RE – New Offices on Land off Duke Street, Hoyland, Barnsley, S74 9QR

Please find enclosed, 3 copies of the amended drawings, as requested, incorporating the changes that you have requested following our discussions.

Drawing No: 1/B.

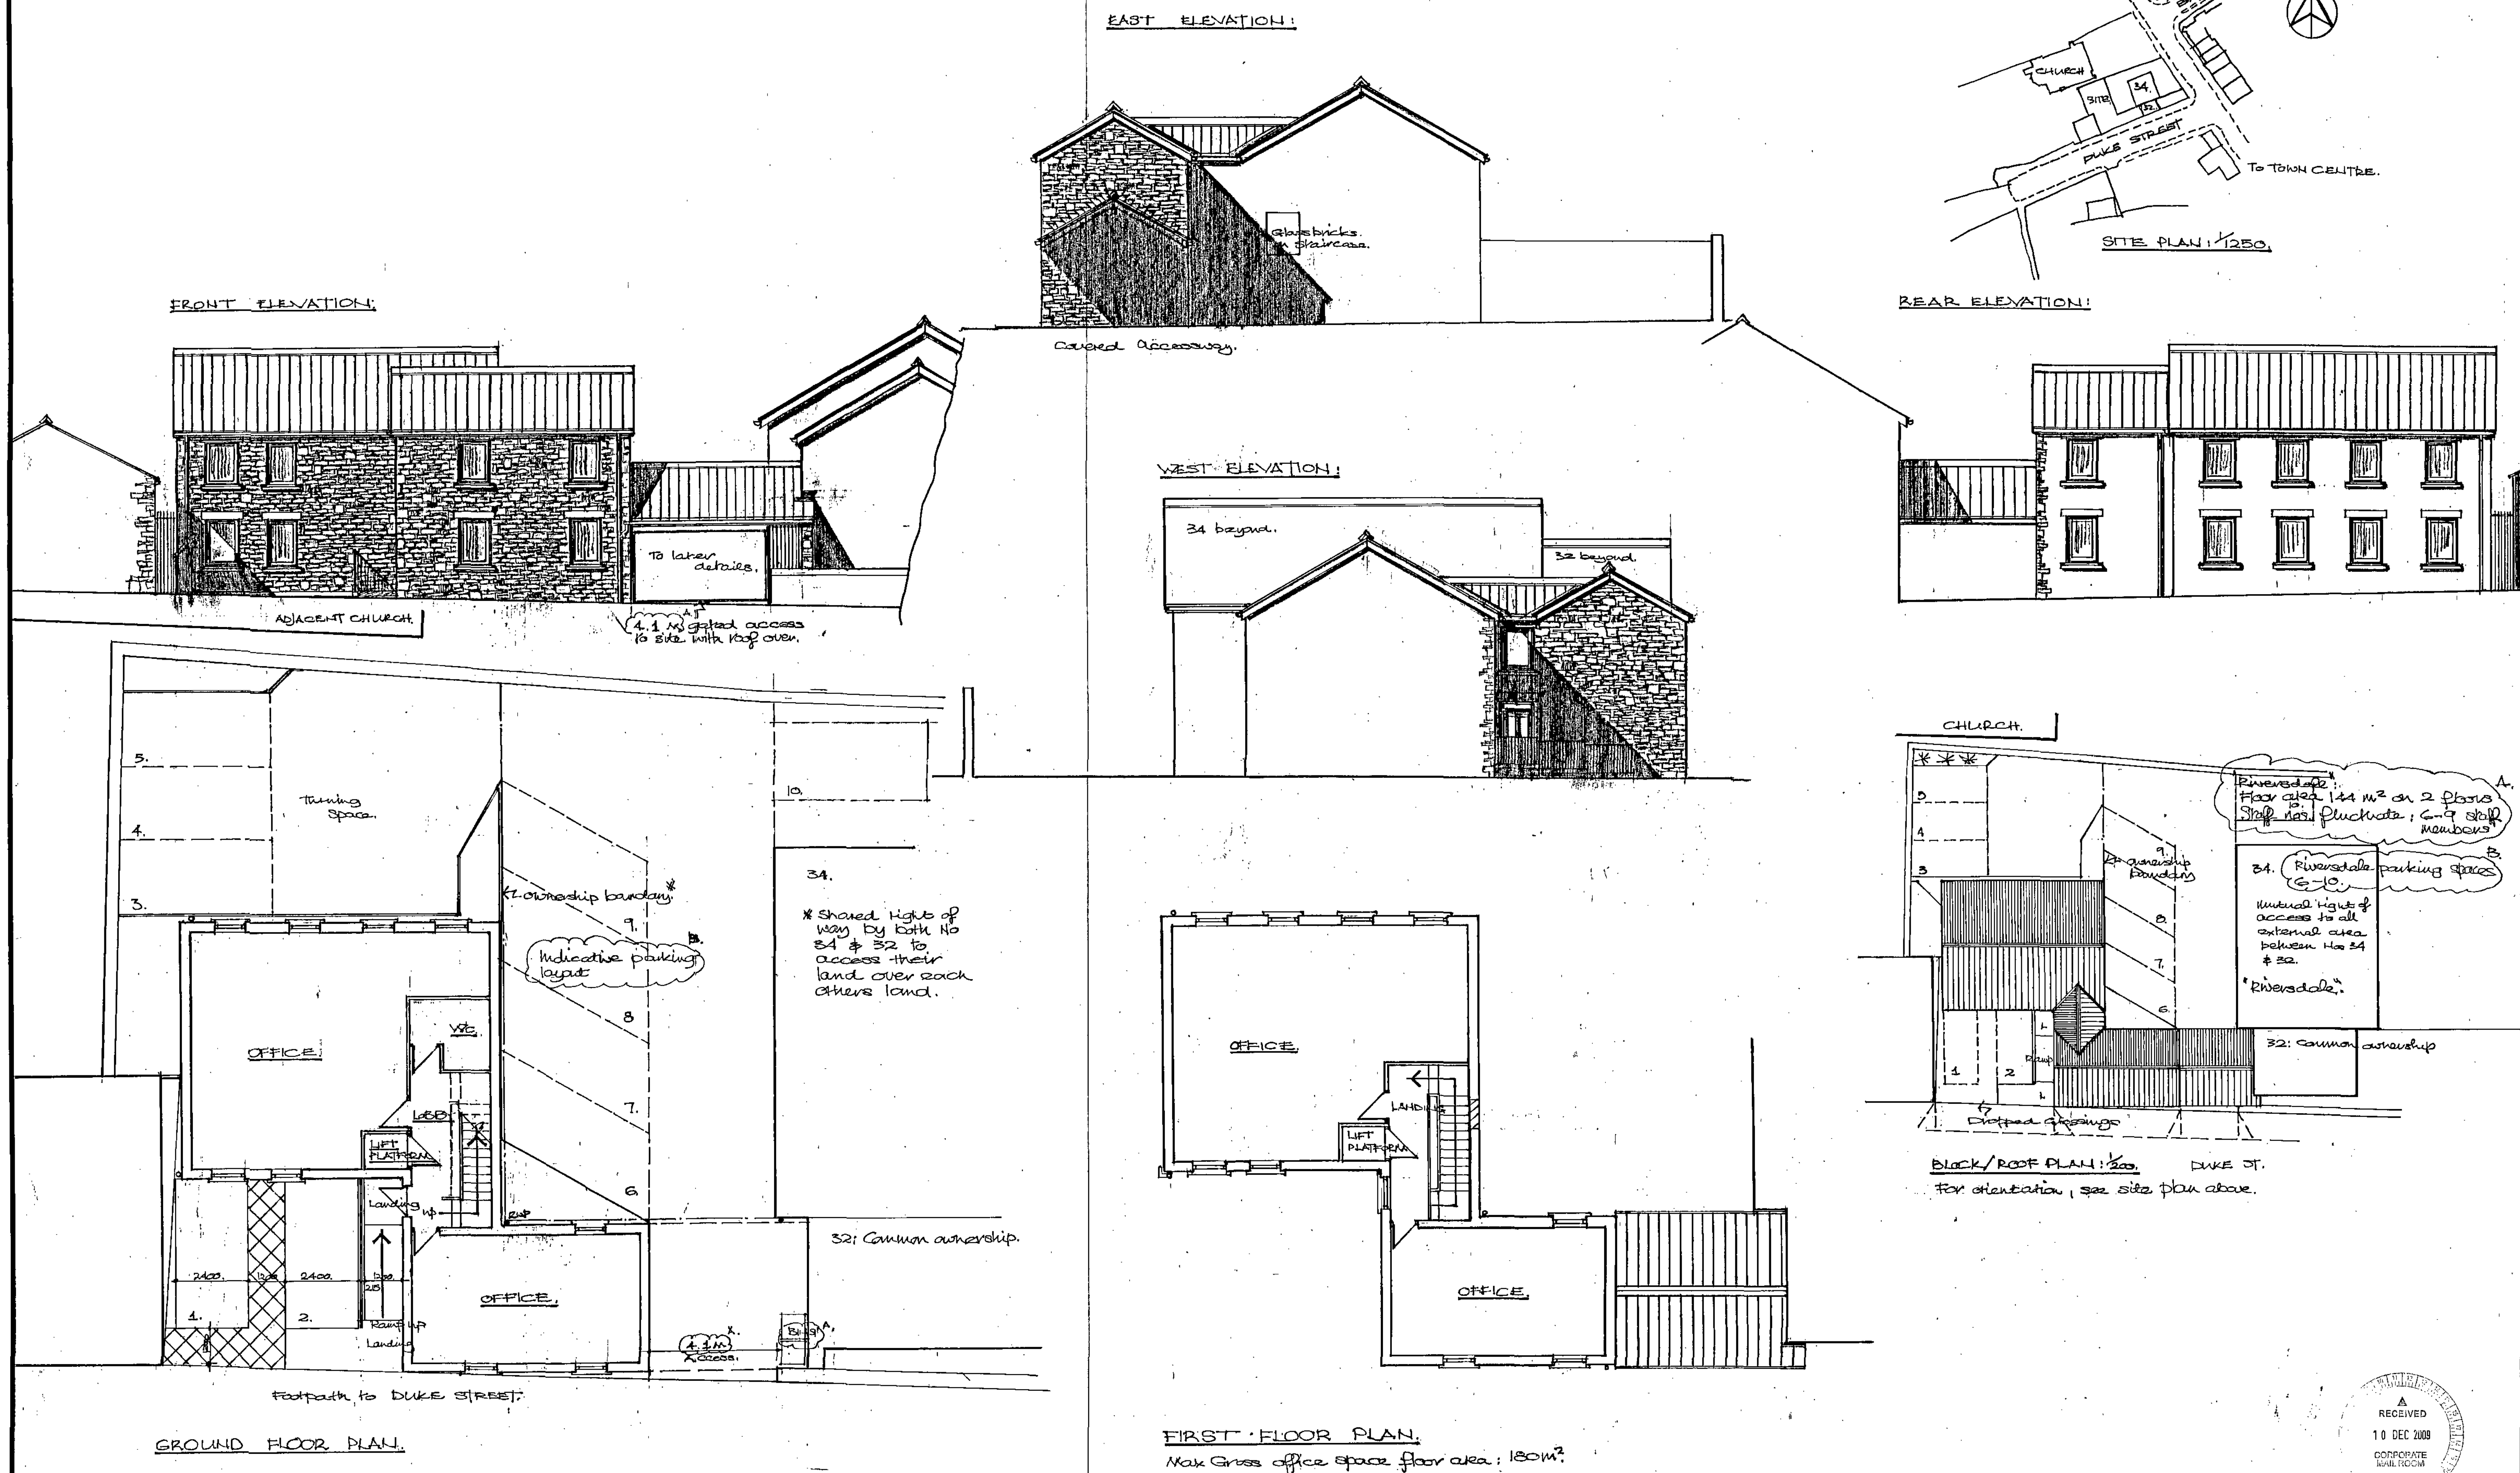
- The re - siting of the Bin store to the front of the site.
- The reduction of the entrance to 4.1m to enable the building, fronting Duke street to be slightly lengthened, thus allowing for more car parking space.
- Details of the office area and staff employment to the adjacent offices of "Riversdale"
- An indicative car parking allocation for the adjacent offices of "Riversdale"
